Planning Application Ref: BN/84/20/PL

Location: Land at Angels Nursery, Yapton Road, Barnham, PO22 0AY

Description of works: **Application for variation of condition 2 (approved plans) imposed on planning permission BN/93/19/PL for the development of 95 dwellings; and consequential changes to other conditions following commencement of development.**

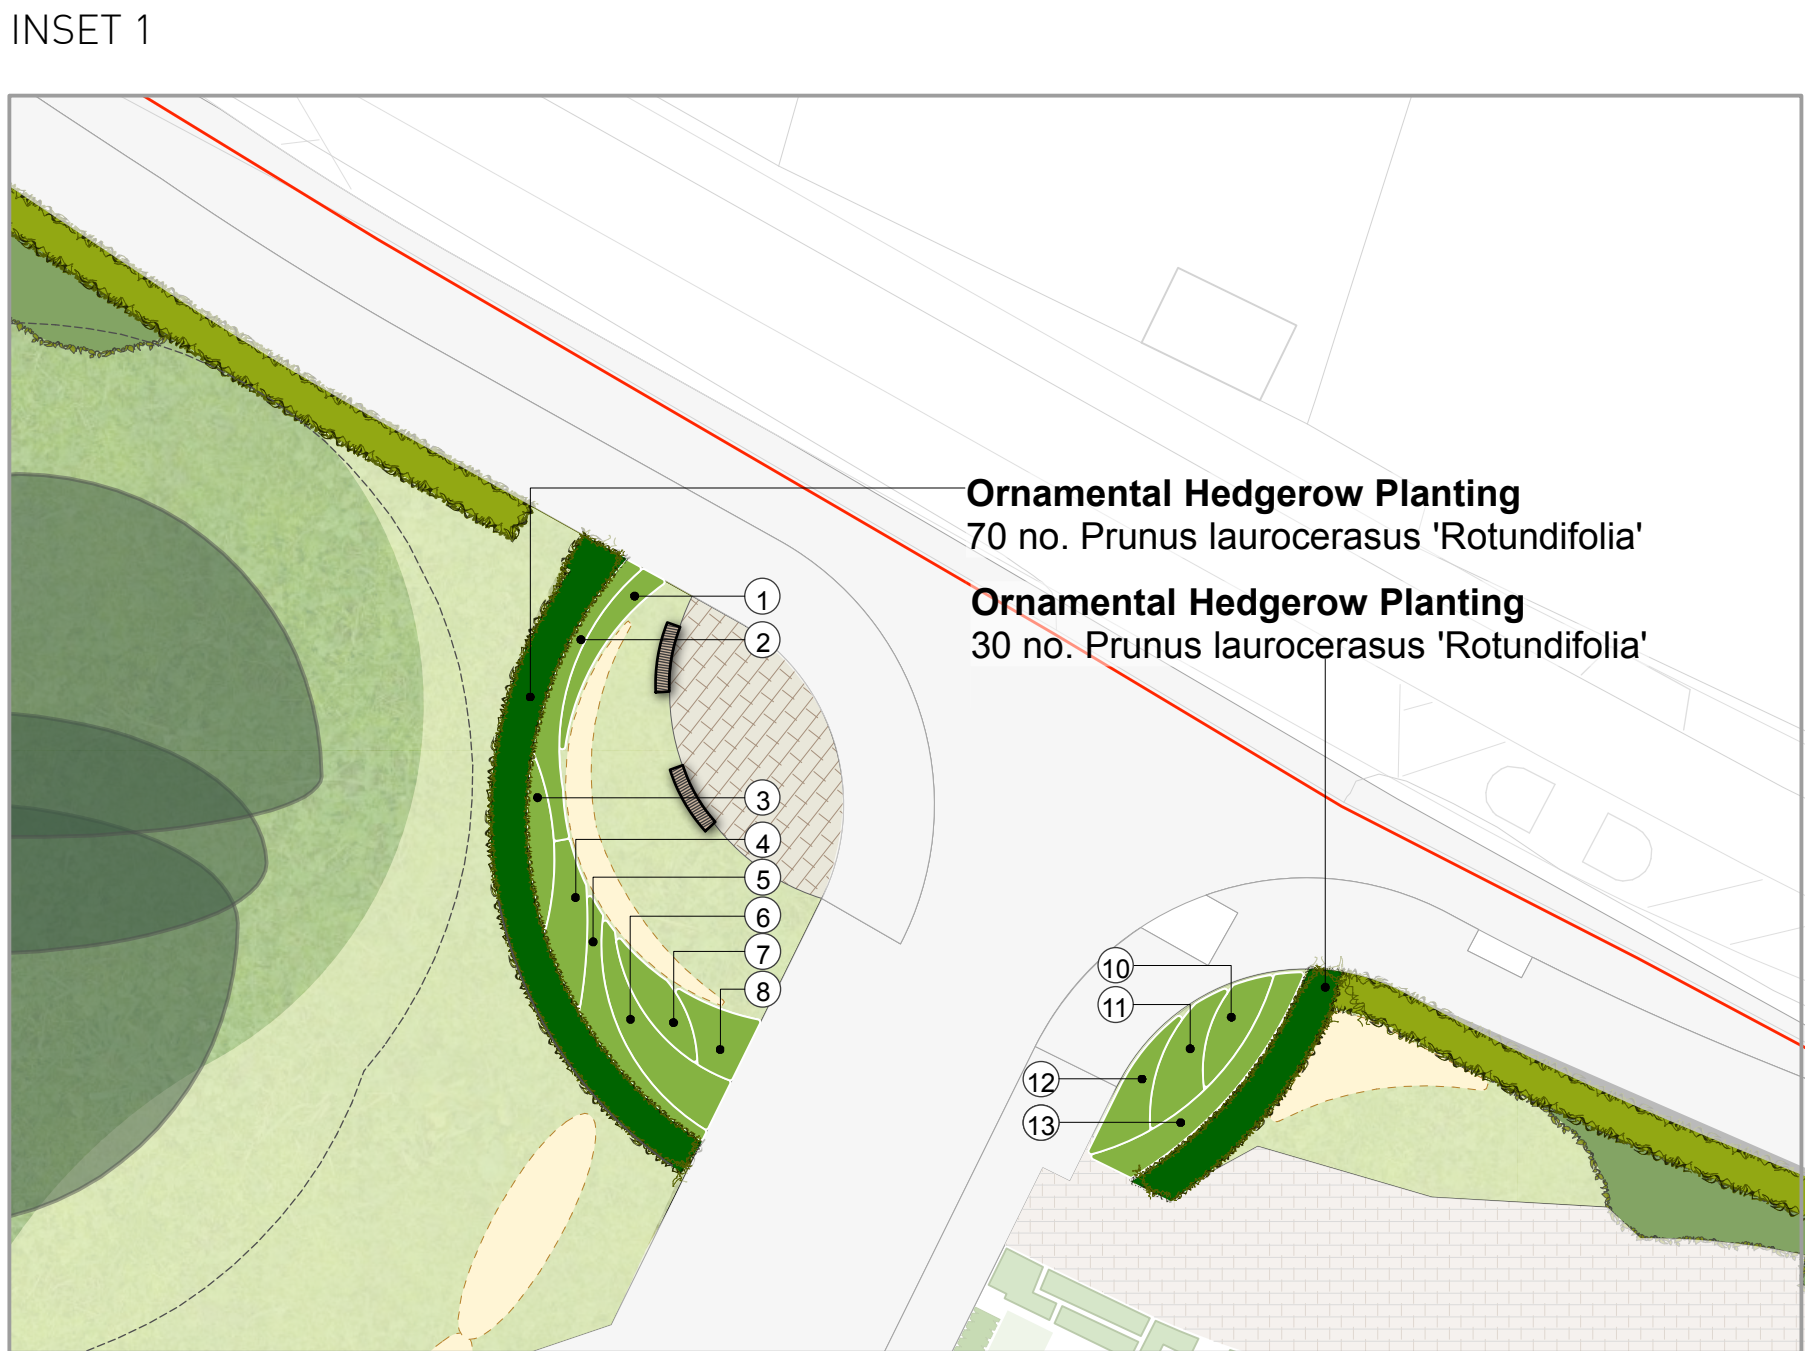
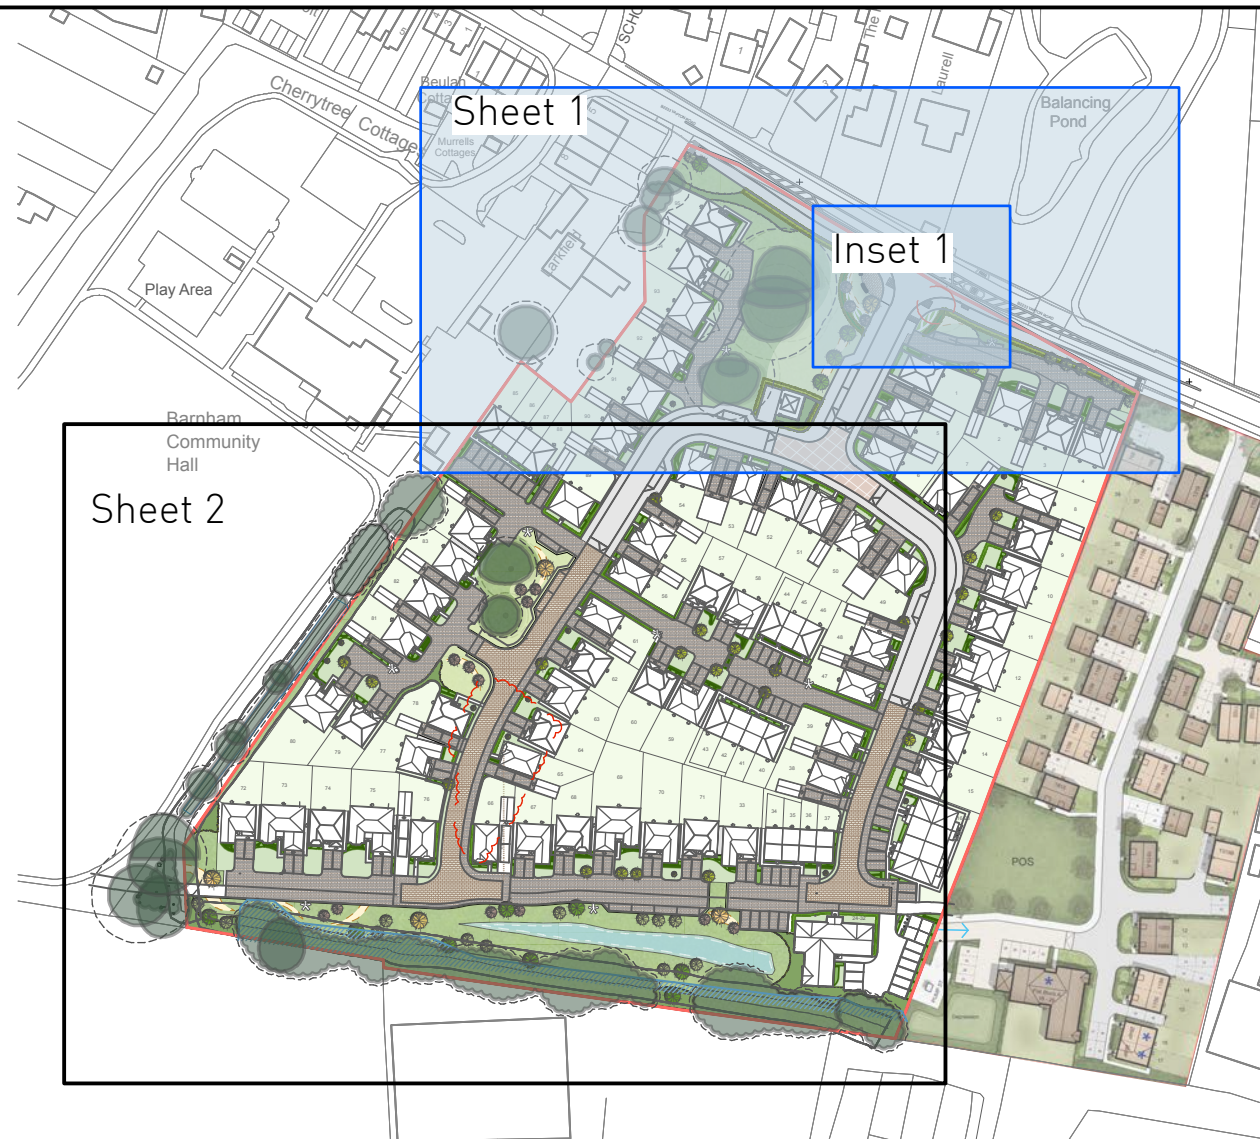
- The intrusion into the RPA of T64 oak and T65 oak (both TPO) is both unsatisfactory and avoidable. These trees need to be given plenty of room to develop into late-maturity without coming under pressure to prune or remove. **UNRESOLVED.** Pruning to facilitate construction now proposed on W aspect of T12 involving crown reduction of 2metres. Future residential pressure to prune further is highly likely due to shade-bearing.

- The group of T85-T87 incl. poplar (TPO) are a management concern post-development being so close to residential dwellings. The proposal of play areas in and about the crown spread of those trees is ill-advised from a safety perspective as well as curtailing their growth potential. **UNRESOLVED.**

- The construction of an attenuation basin along the southern boundary would involve the grading of soil (excavation) from deep within the RPA of substantive tree groups G5 and G6. This is a far from ideal proposal and there is a high probability of significant harm to trees.
